Ryde - Hunter's Hill Flora and Fauna Preservation Society

Ms Natasha Harras,
Department of Planning and Environment,
23-33 Bridge St, Sydney NSW 2000
17.7.15

**RE: S96 Modification Application SSD_5093 - M2 Site, North Ryde Priority
Precinct**

FIGURE 2 – PLAN OF PROPOSED GAS MAIN RELOCATION (REFERENCE: C-0-9-20)

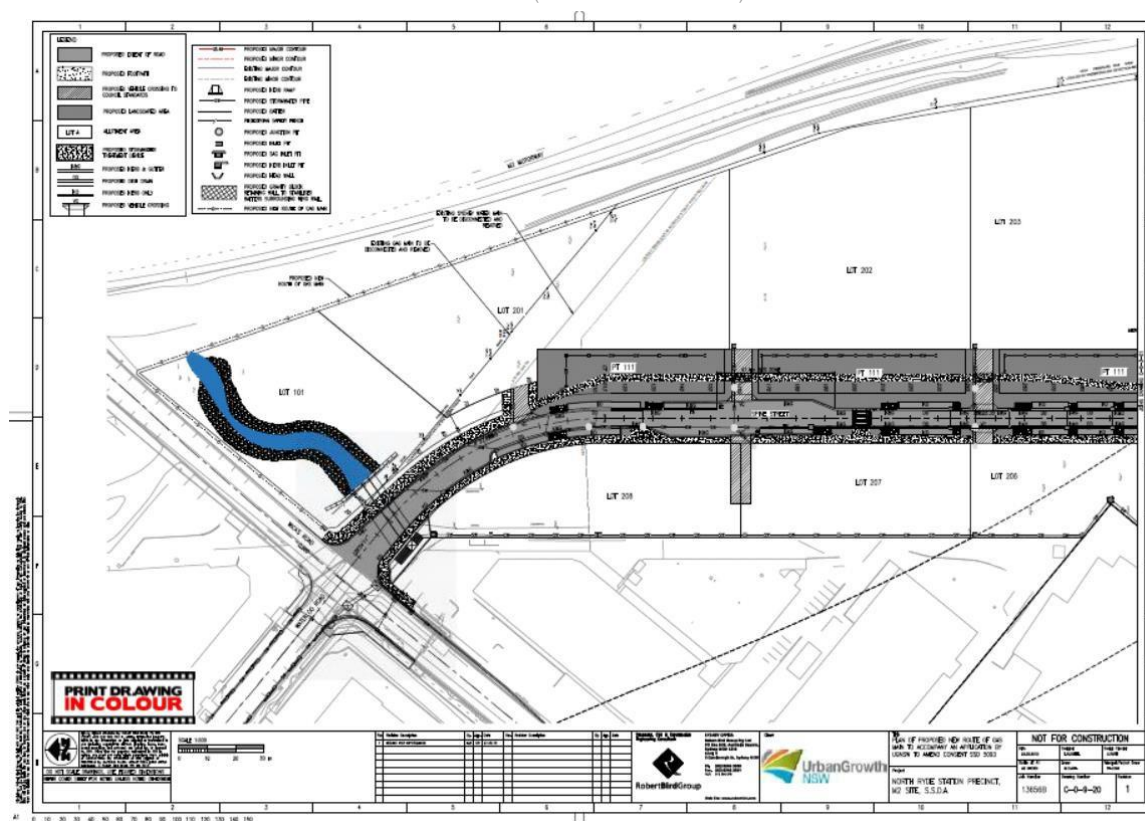
- a) both the approved, and proposed new, routes of gas line create potential conflicts;
- b) the relocated gas line is not marked on the maps included in the ecological report and it is unclear where it is located in relation to the existing concrete culvert servicing the M2 Tollway;
- c) we remain unclear how the new section of gas line fits within the existing gas infrastructure network;
- d) what remediation of the relocated line will occur, will it assist habitat connectivity and who is responsible.

However, the supporting documents to the amended plans do not indicate where the new gas line will run in relation to the existing concrete culvert.

So as to identify conflicts associated with the proposed amended route of the relocated gas line it could be useful to consider how the gas line and culvert will function together in a close location. Presentation of their interrelatedness on a plan would seem a basic requirement.
